RE: THOMAS STREET CAR PARK SITE MODIFICATION 7 OF MP09_0066 (Our ref: S090002)

I refer to your emailed advice dated 16 May 2013 on lodgement by the Meriton Group of a further modification of the approved development on the Thomas Street Car Park site in Chatswood. The approved development in this case means, as indicated in the letter lodged with the application by Meriton Group, the development as approved in Modification 3 of MP09_006 dated 18 February 2013.

Comments on Modification 7

A-0100 D
CONSTRUCTION CERTIFICATE

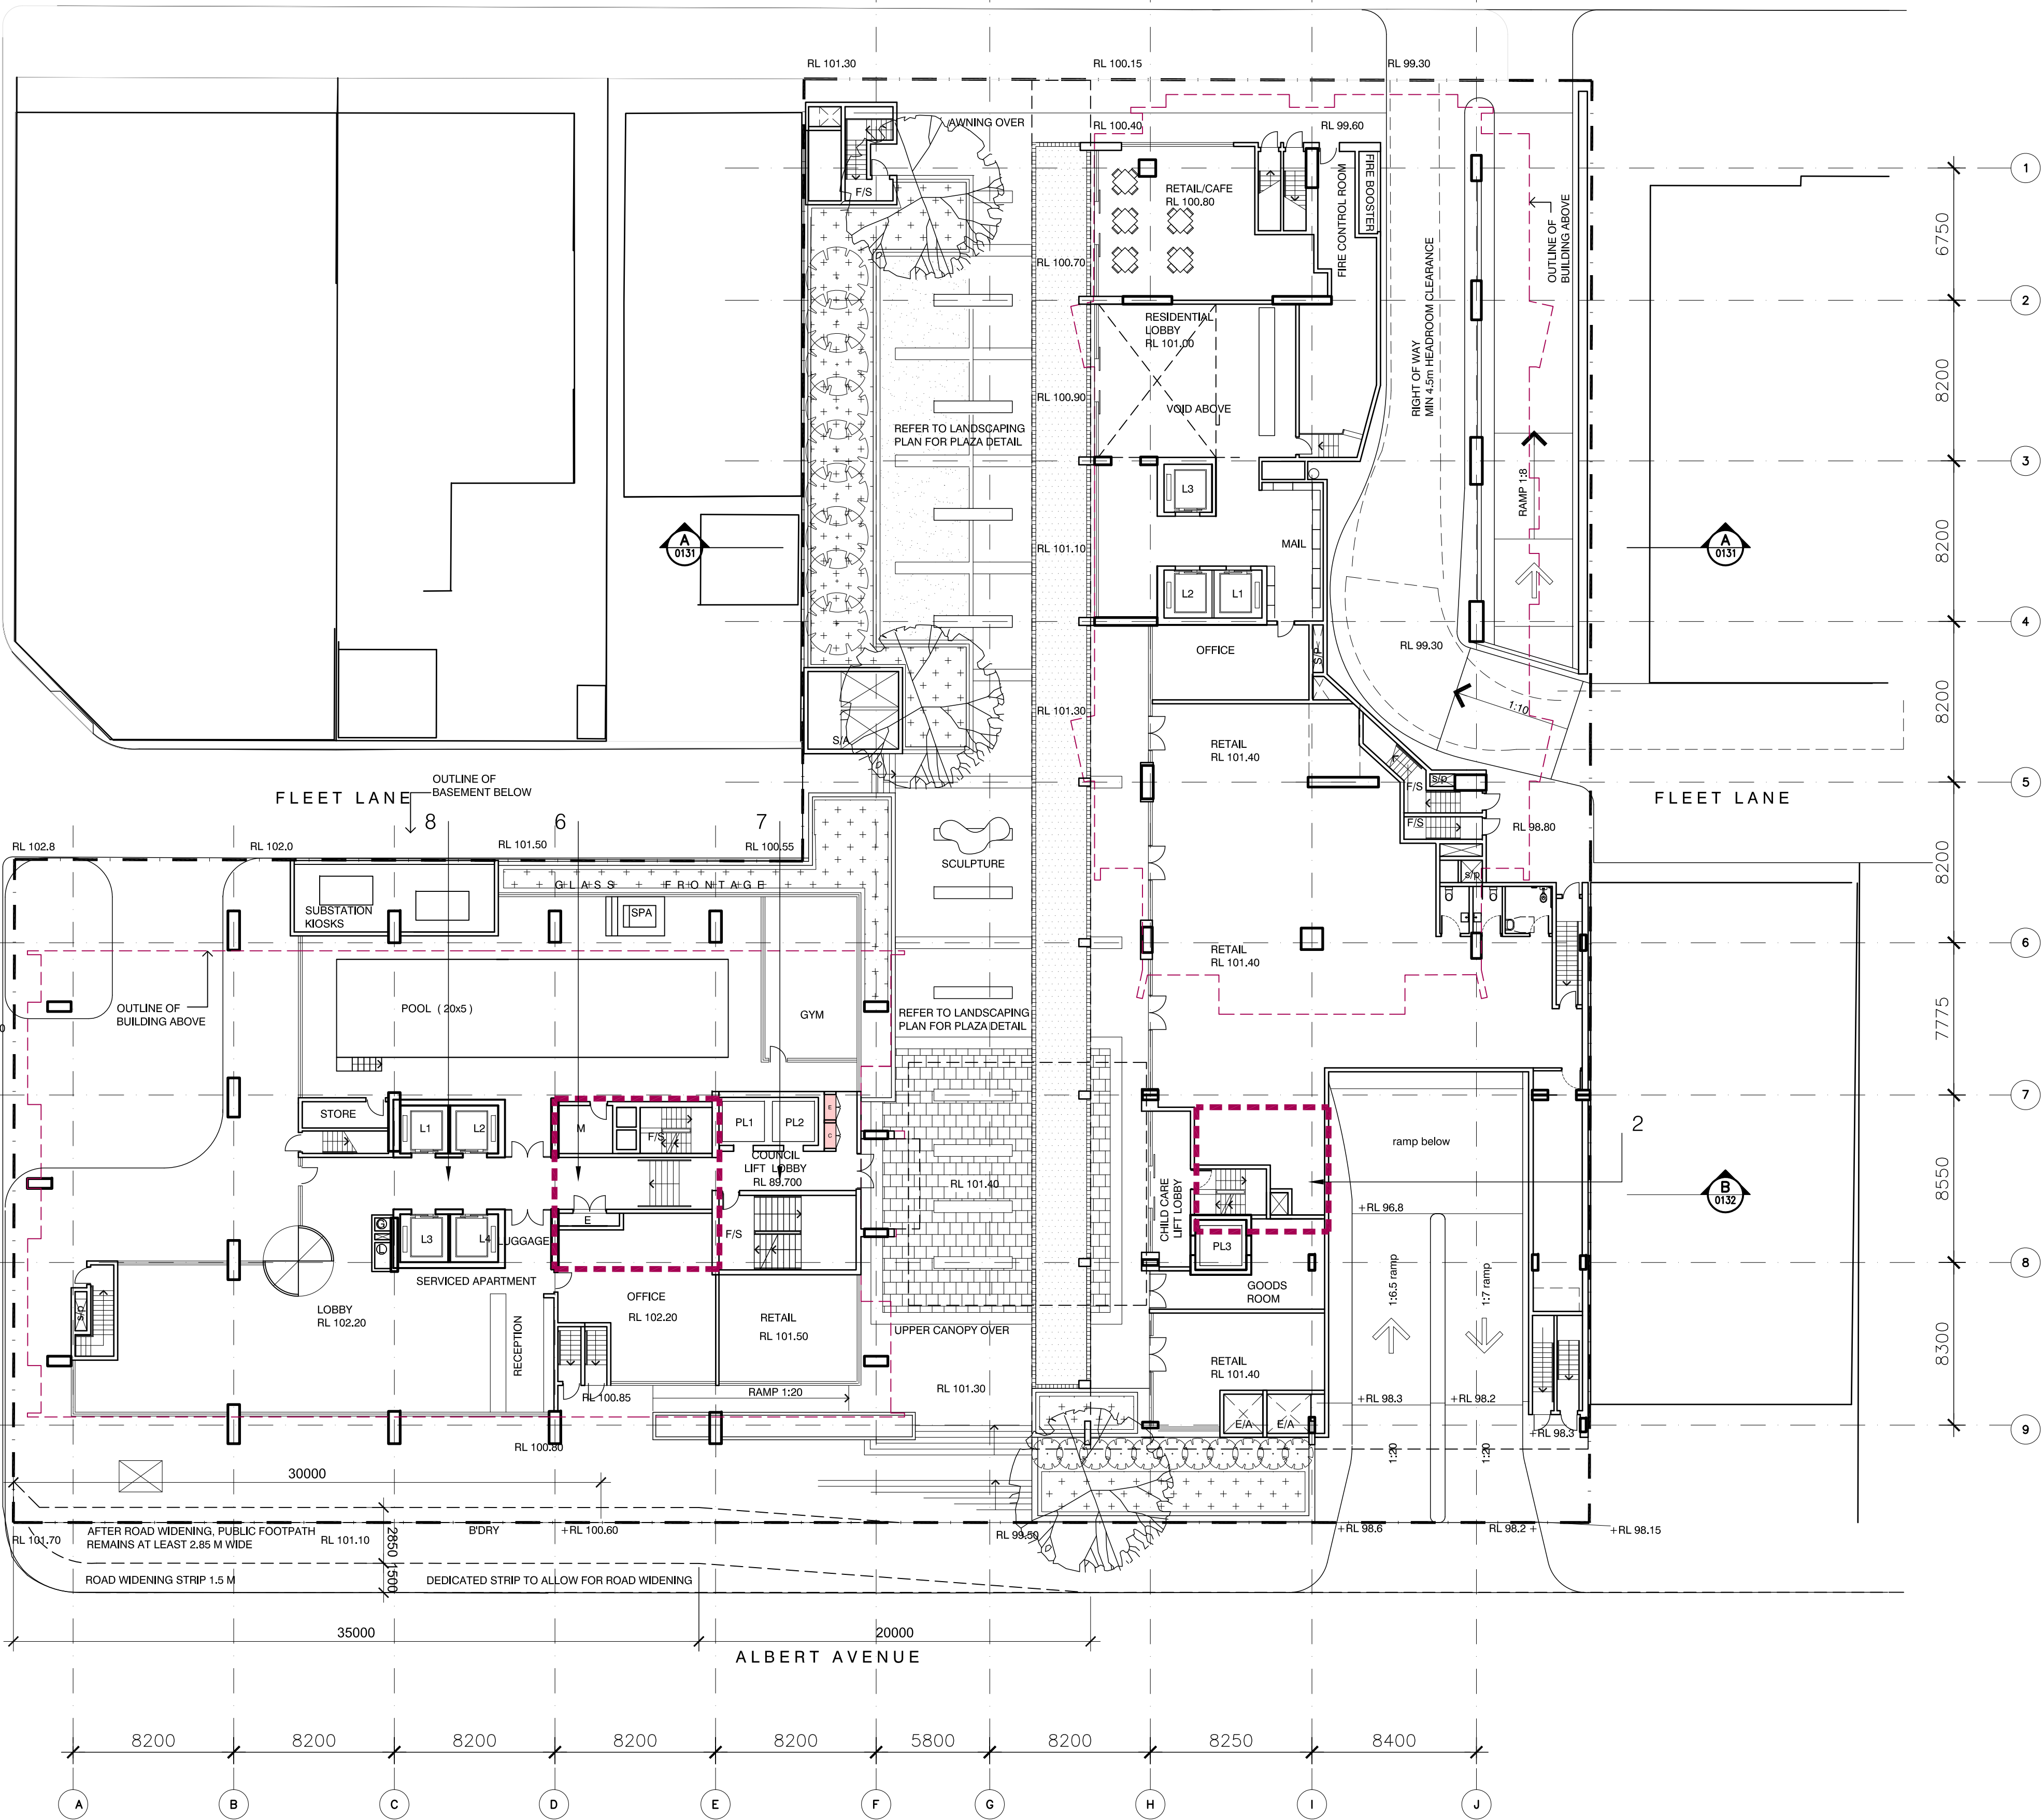
Council notes that the plans lodged with the application did not provide the mezzanine and ground floor plans that are impacted by the change to the locations of the serviced apartment and public car park lift cores. The documentation also did not deal with the how the service apartment guest would move from the serviced apartment car parking to the serviced apartment tower lobby as the serviced apartment tower lift does not now access the basement car parking.

To fully understand the intention of proposed Modification 7 affecting Modification 3 Council was provided with two additional plans by Meriton Group being A-0100/D for the ground floor and A-0110/D for the basement mezzanine.

Furthermore the amended plans, despite the advice that the serviced apartment guests may use the residential lift to the ground floor and then cross the plaza, the layout of the car parking and location of the public lifts indicates that the serviced apartment guest will more likely cross into the public car park and use the Council car park lifts to access the serviced apartment foyer and tower. This is unacceptable as the lifts for the public car park must operate separately and for the exclusive use of the public car park as they will be owned and maintained by Council. Again the issue is that the public car parking facility in its entirety needs to be separate.

A-0112 F
CONSTRUCTION CERTIFICATE

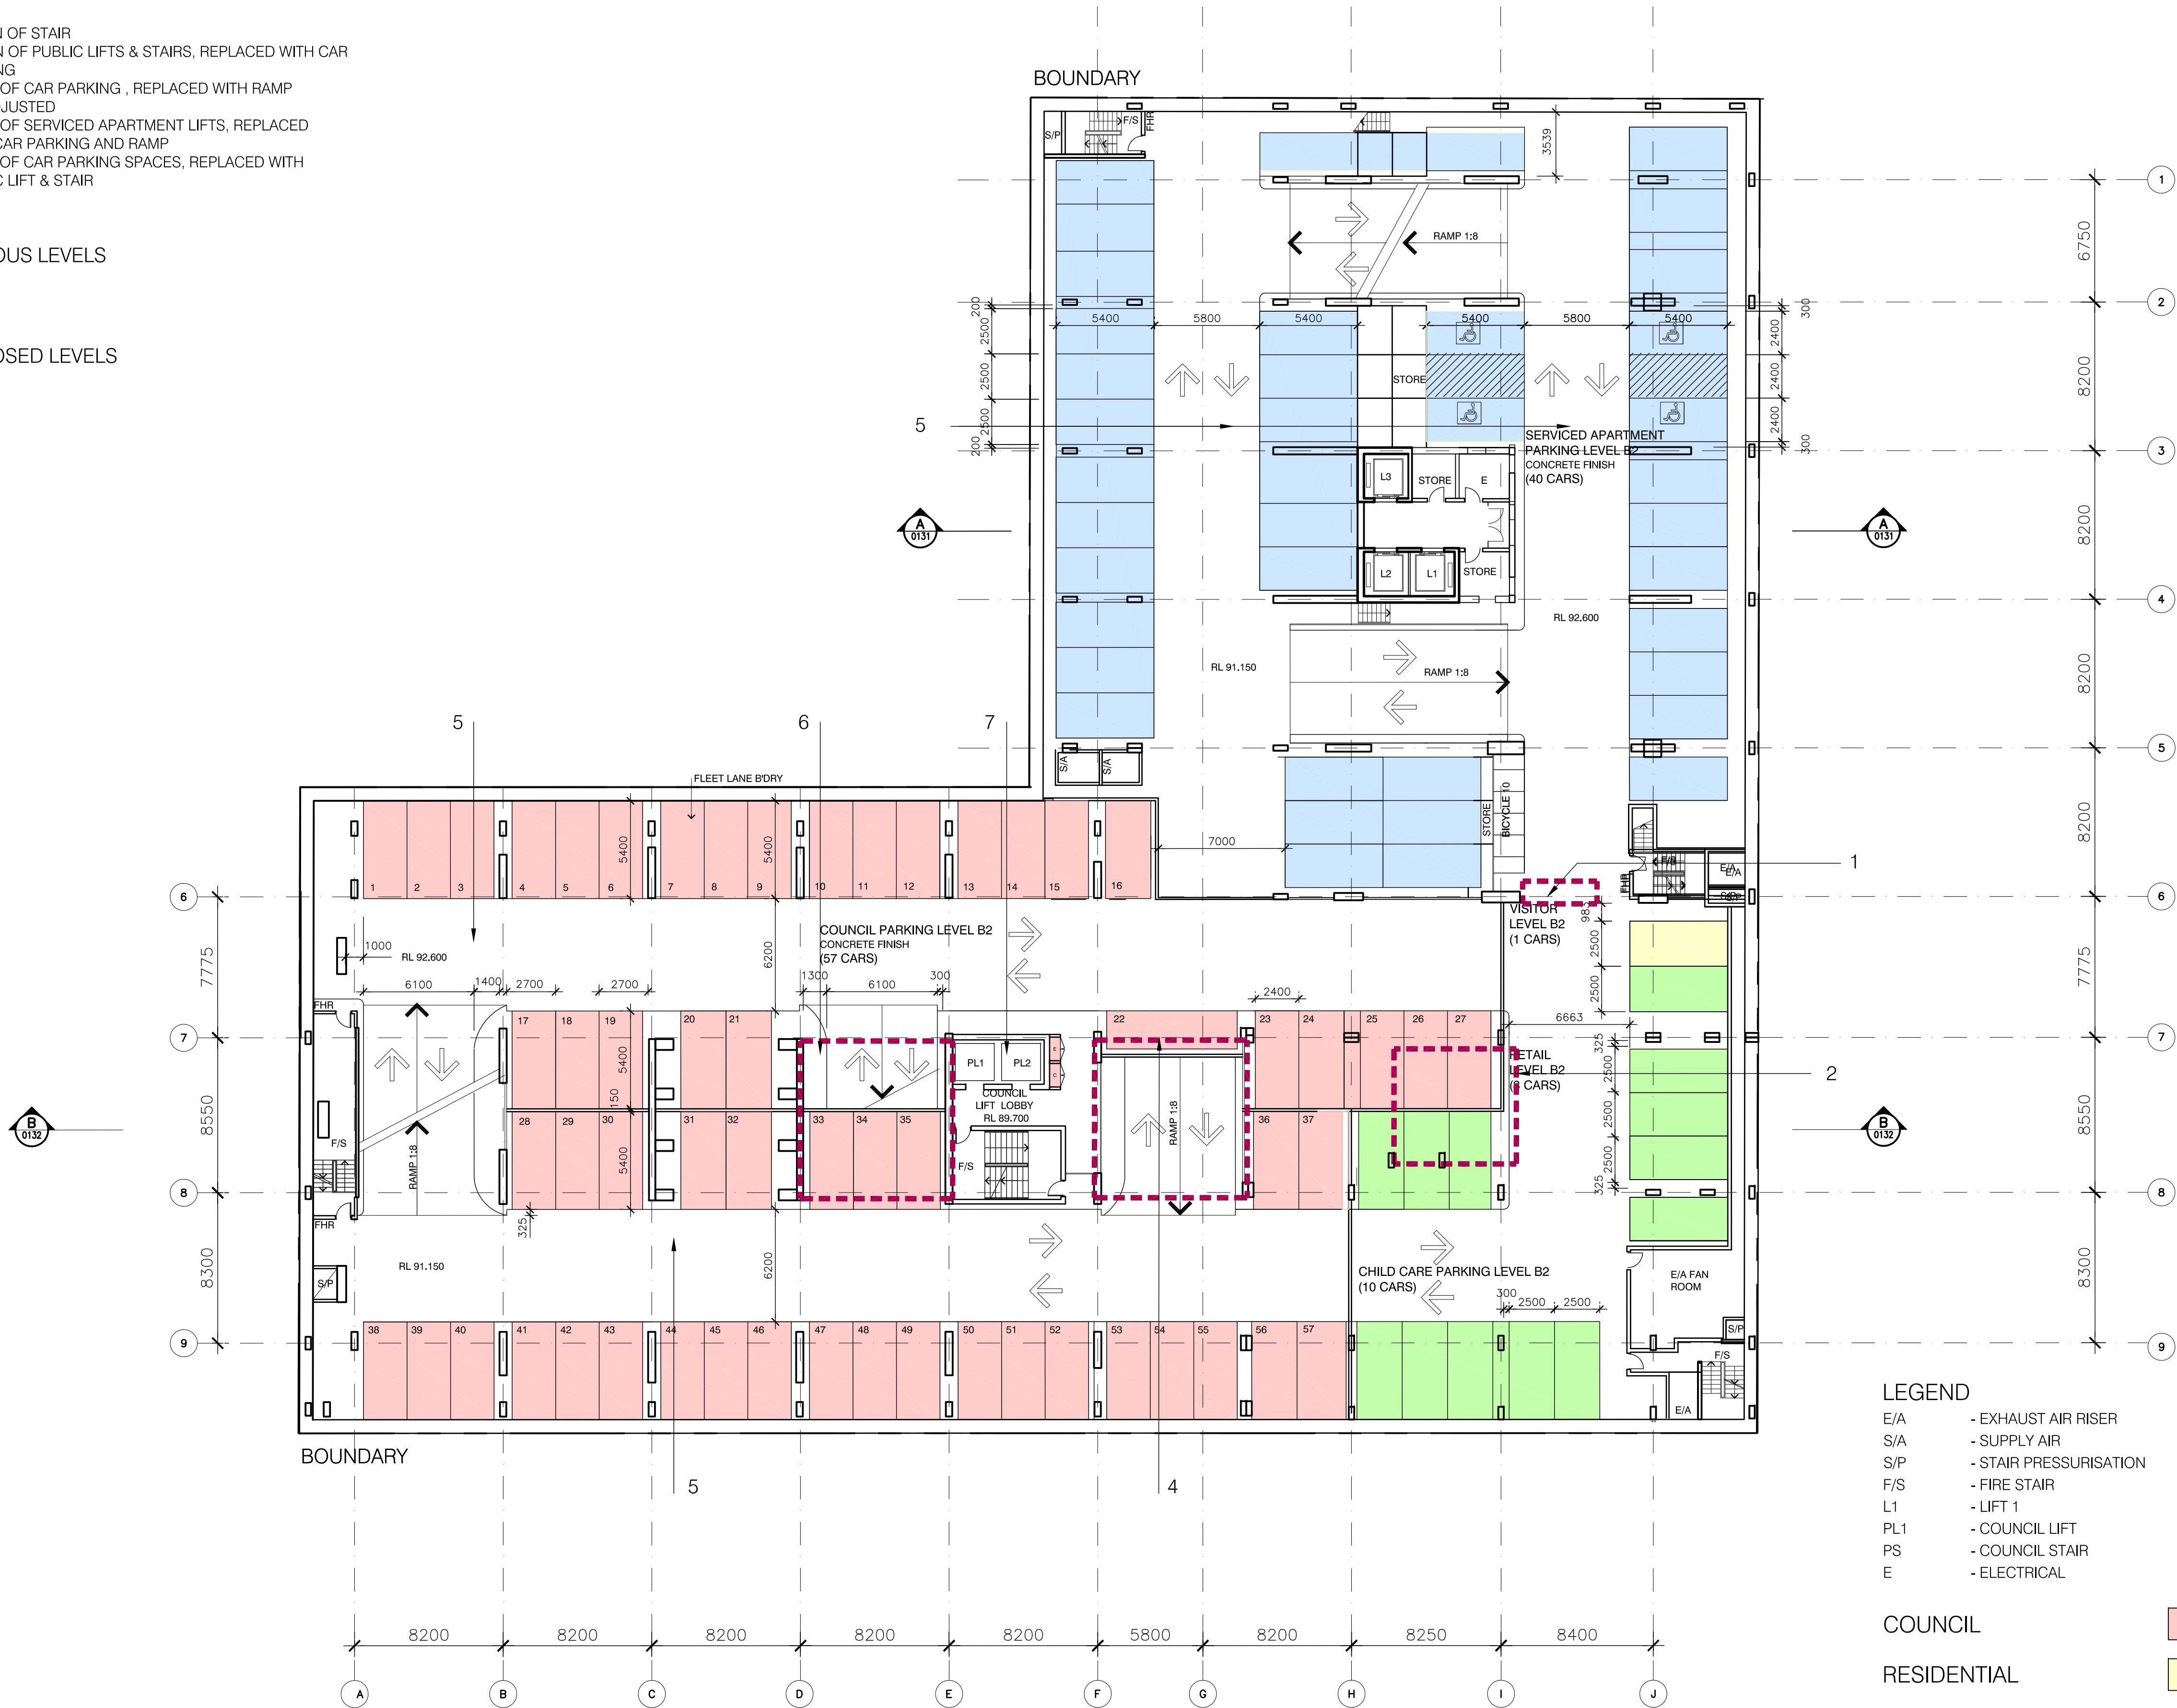
6. Provision of the child care and retail spaces (13 in total) on Basement 2 partly under the residential tower and partly among the public car parking spaces.

The plans provided go part of the way towards consolidating and separating the public car parking from the car parking for the development on the site. However, as Council has previously advised, the public car parking should be completely separated and accommodated over a minimum number of levels of the basement and occupy the full width of the southern part of the site. The plans submitted still have a lack of separation with the resulting operational consequences in confusion between the public and development car parking. This also has consequences in utility services and separation of the Council owned facility from the operational infrastructure and maintenance of the rest of the development. The Council facility will be separately maintained and operated by Council. The public car park has been repeatedly noted to be a separate land use and entity in the development that is not to be tied to any arrangement involving the residential or serviced apartment components.

A final comment is that the current plans require review as there are inconsistencies in the plans. The residential lift core indicates the provision of three lifts in the tower, three lifts on the ground floor, four lifts on Basement 1 and two lifts servicing Basements 2 to 5. On Basement 1 the slope on the circulating aisle within the public car park has been retained going from RL 96.40 down to RL 94.950. As the floor level of Basement 2 below the location is a constant RL 92.60 this means that the floor to floor level is in part is only 2.35 metres which will not work. The floor to floor level needs to allow for the depth of the concrete floor slab and compliance with Australian Standards for unobstructed clearance in public car parks below the sprinklers, services, directional signage etc.
